City of Albuquerque Stormwater Construction Site Inspection Report

ESC File No.	K10E066	Project Name:	D&B U Sell It		
NPDES Id. No.	NMR1006GO & 69D	Location:	401 Unser Blvd. and 8530 Bluewater Rd. NW		
6/17/2024	Owner		Contractor		
Operator	D&B Limited Trust, LLC		Alliance Paving Company		
Contact name & title	Miriam Ruiz		Jose L. Flores & Joseph Cruz		
e-mail	miriamruiz@yahoo.com dblimitedtrust@		jflores@allianceconinc.com		
Contact Phone #	505-884-3578		505-991-2467		
COA Inspector	James Hughes		Start/End Time:	10:00 AM	
Construction Phase:	Grading				
Type of Inspection:	Regular	Storm Event	Post Storm Event >0.25"	311/Complaint	Follow Up
Weather at time of inspection?	Clear		Temperature:	~ 99	
Estimated date of last storm 0.25" or greater	4/17/2024

DRAWING:	DRAWN BY:	DATE:	SHEET #
BLUEWATER.DWG	SH-B	2/22/2024	1 OF 2

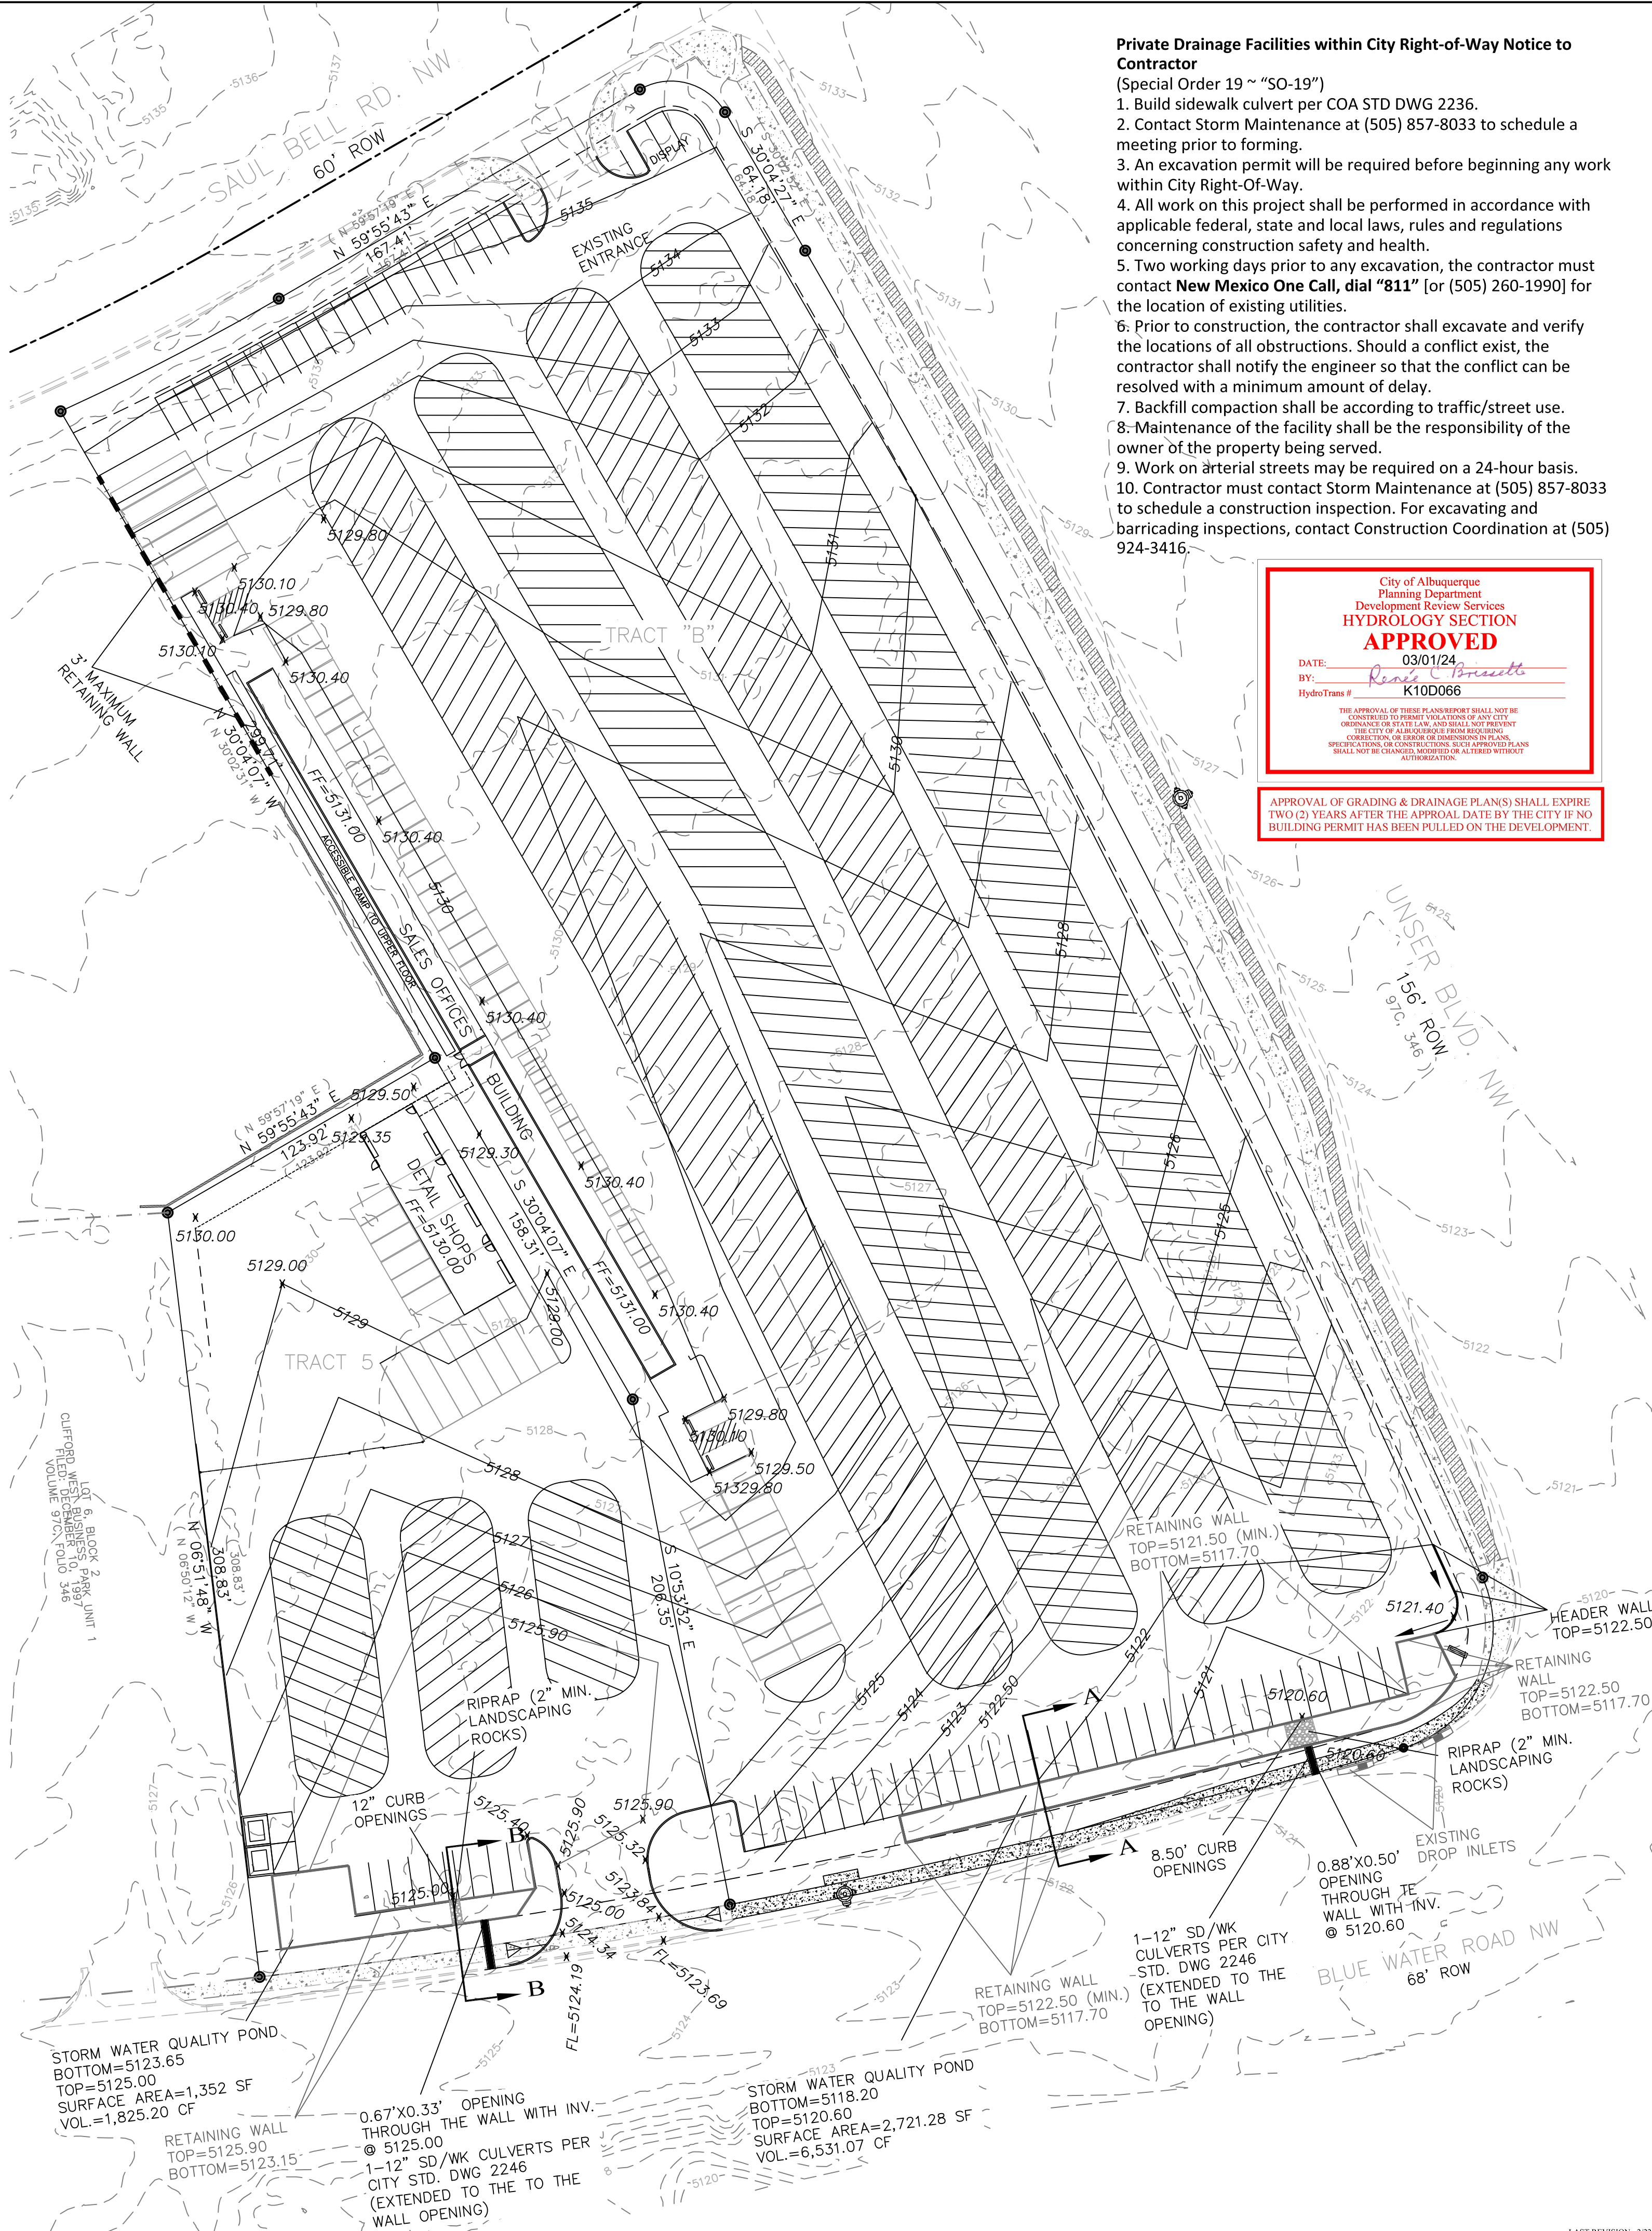
Item Number	Deficiency/ Corrective Action			
1	BMPs — The pond(s) volume looked too small and was located east of the concentrated flow path, which appears to exit the site west of the small pond in violation of CGP 2.1.2. The pond installation was incomplete in violation of CGP 2.1.3, with inadequate volume, concentrated flow path bypasses the pond, and the overflow wasn't stabilized. Sediment Trap design volume calculations and Construction specifications were missing in violation of CGP 2.2.12 and the city's ESC Plan checklist. Required Mitigation: CGP Part 2.1.2 requires you to design and install all stormwater controls in accordance with good engineering practices, including applicable design specifications. You must finish the sediment basin design per CGP 2.2.12, including design calculations and construction specifications. The ESC Plan and pond design must be submitted to the City of Albuquerque for review and approval per Albuquerque's Erosion and Sediment Control (ESC) ordinance § 14-5-2-11. You must also complete the installation before the next city inspection per the city ordinance and the escalation process. You must also ensure all stormwater controls are maintained and remain in effective operating condition during permit coverage, per CGP Part 2.1.4. If at any time you find that a stormwater control needs routine Maintenance, you must immediately initiate the needed maintenance work and complete such work by the close of the next business day per CGP 2.1.4.b. When the problem requires a new or replacement control or significant repair, install the new or modified control and make it operational or complete the repair by no later than seven (7) calendar days from the time of discovery per CGP 5.2.1.
